Address: Dulas, 60 Clumber Drive Cleckheaton BD19 4RP

Application number: 2024/91451	
What is the application for?:	Erection of detached dwelling with associated external alterations and erection
Address of the site or building:	88, Shirley Road, Gomersal, Cleckheaton, BD19 4ND
Postcode:	BD19 4ND

### User comments

| Title: - Tree Information Plan | |

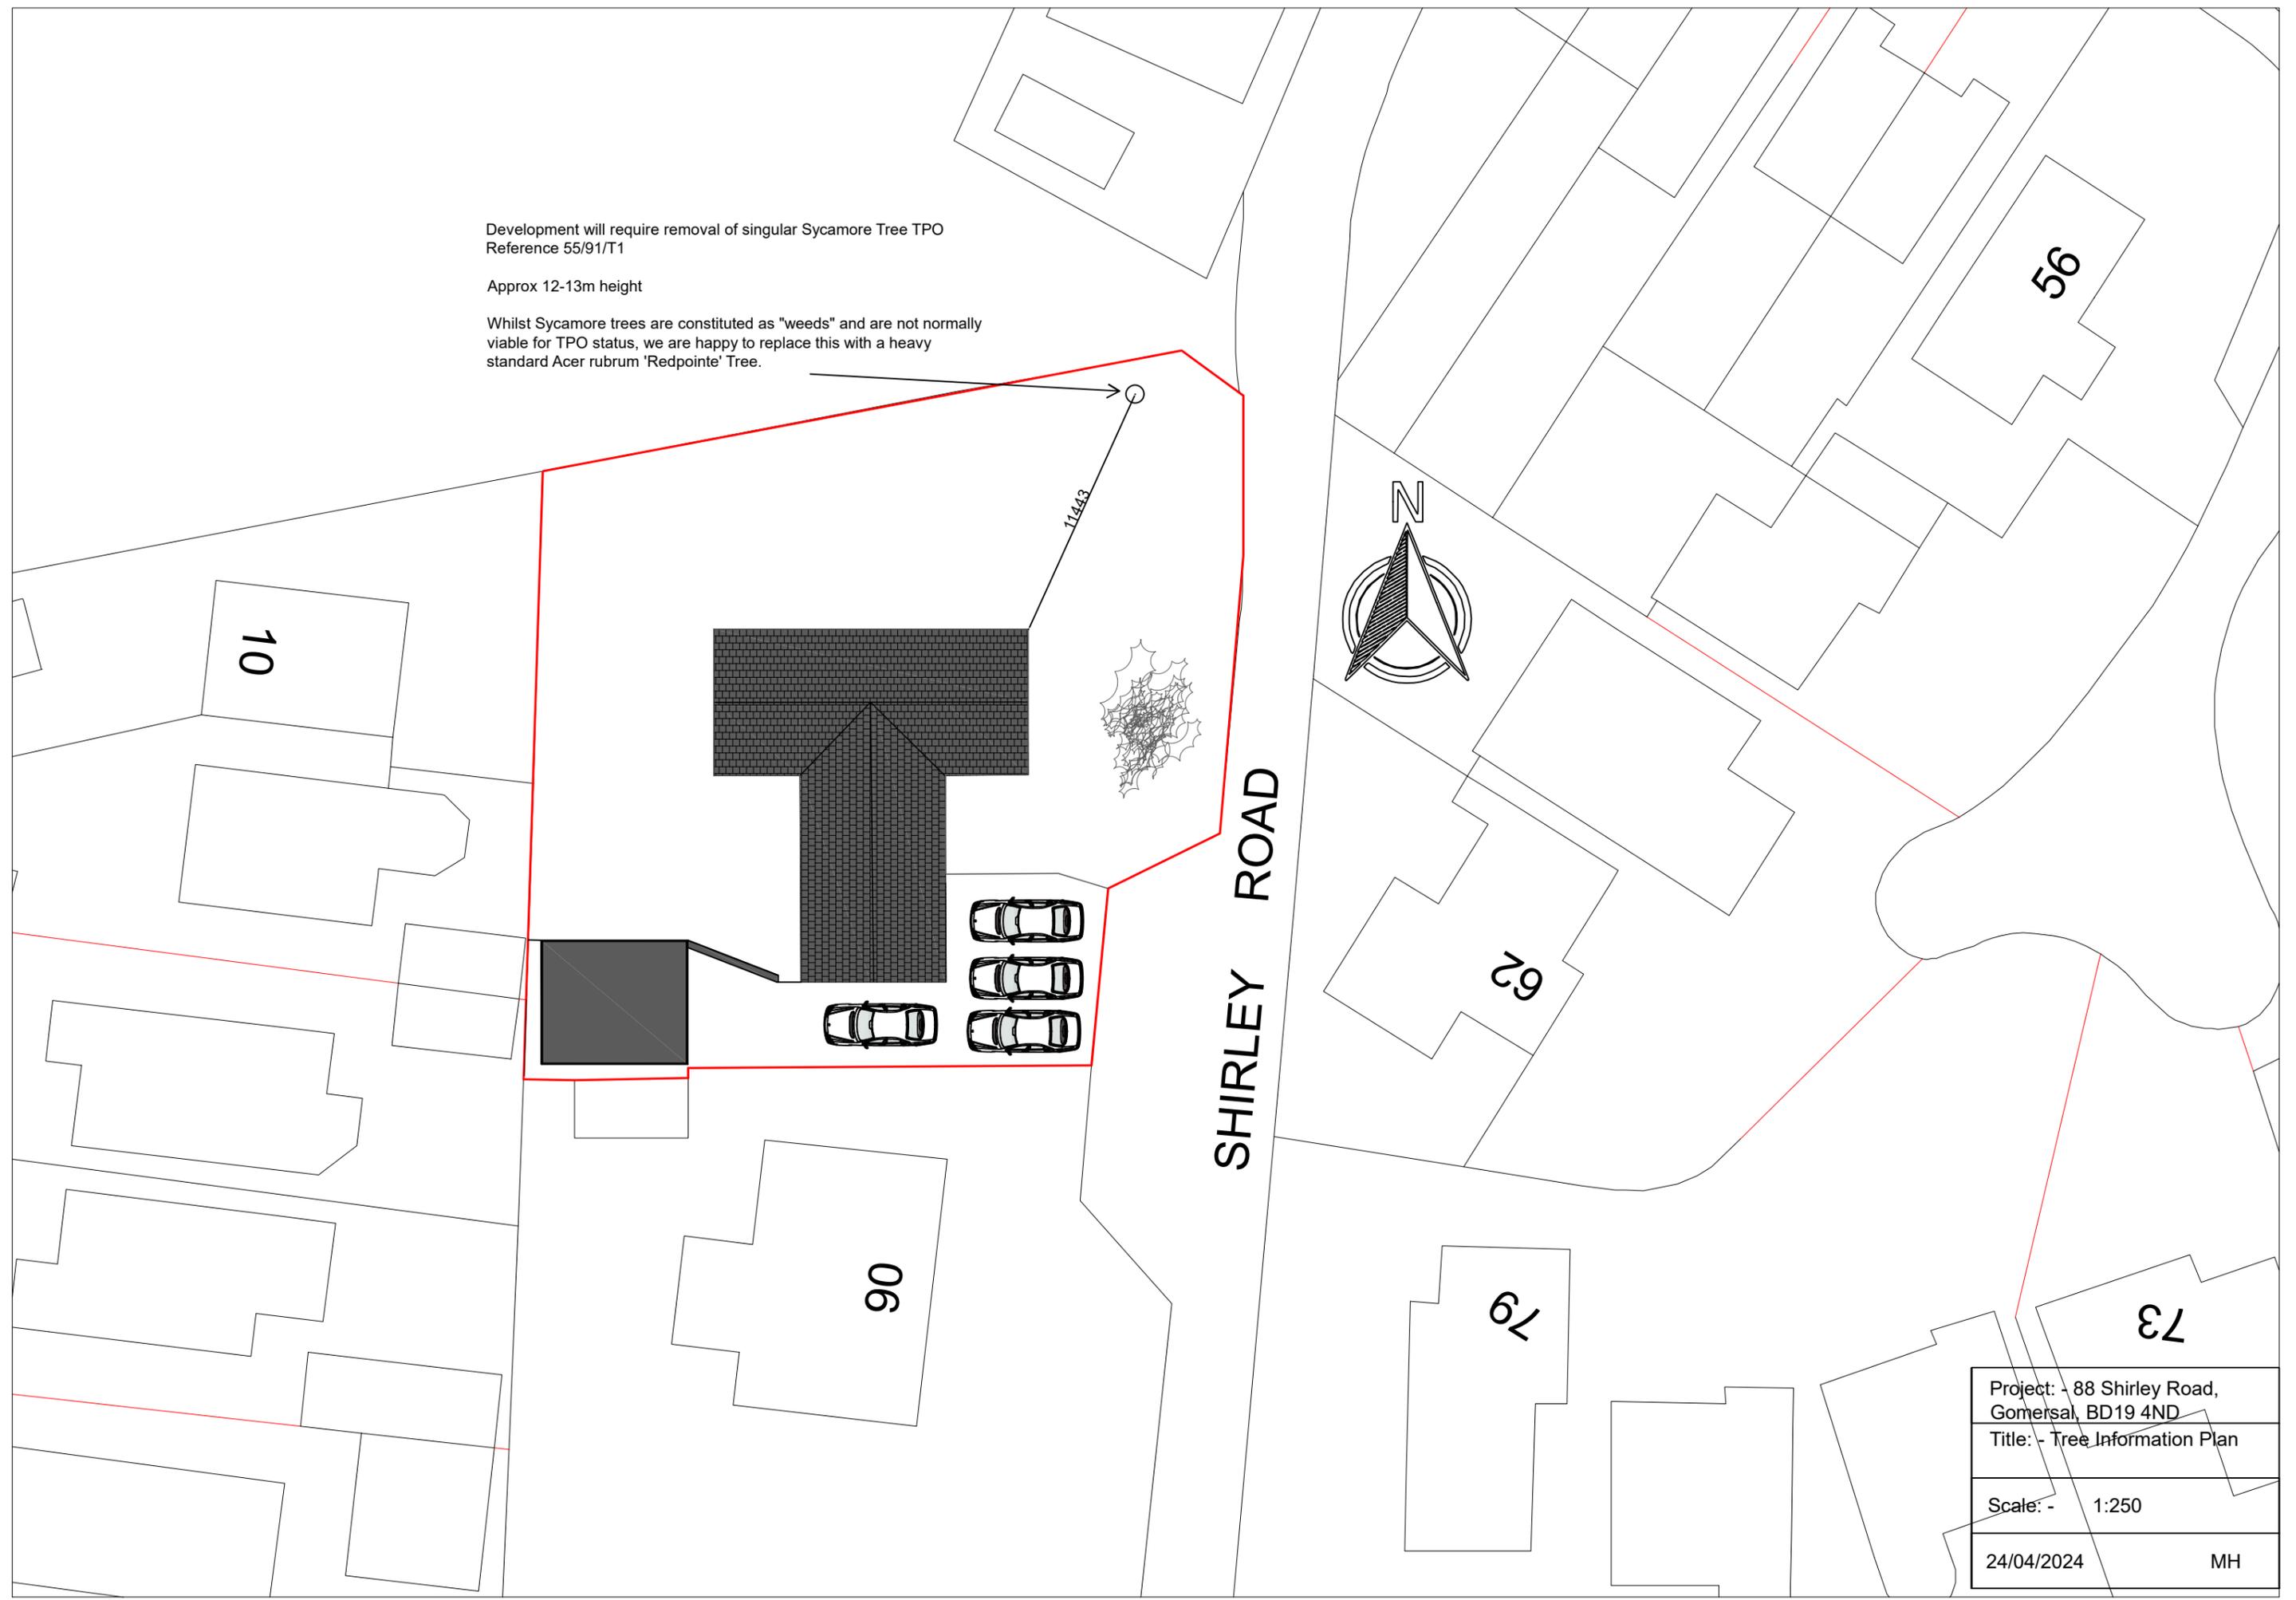
Type of comment: A general comment	
Do you wish your comments to be published on the website anonymously?	No
Has a risk assessment been undertaken to determine the likely impact on building structures that are in close proximity to the large Sycamore tree that will be removed? We have a large stone garden wall about 10 meters from the tree and wish to be reassured that it will not be damaged by subsidence or ground heave cause by its removal.
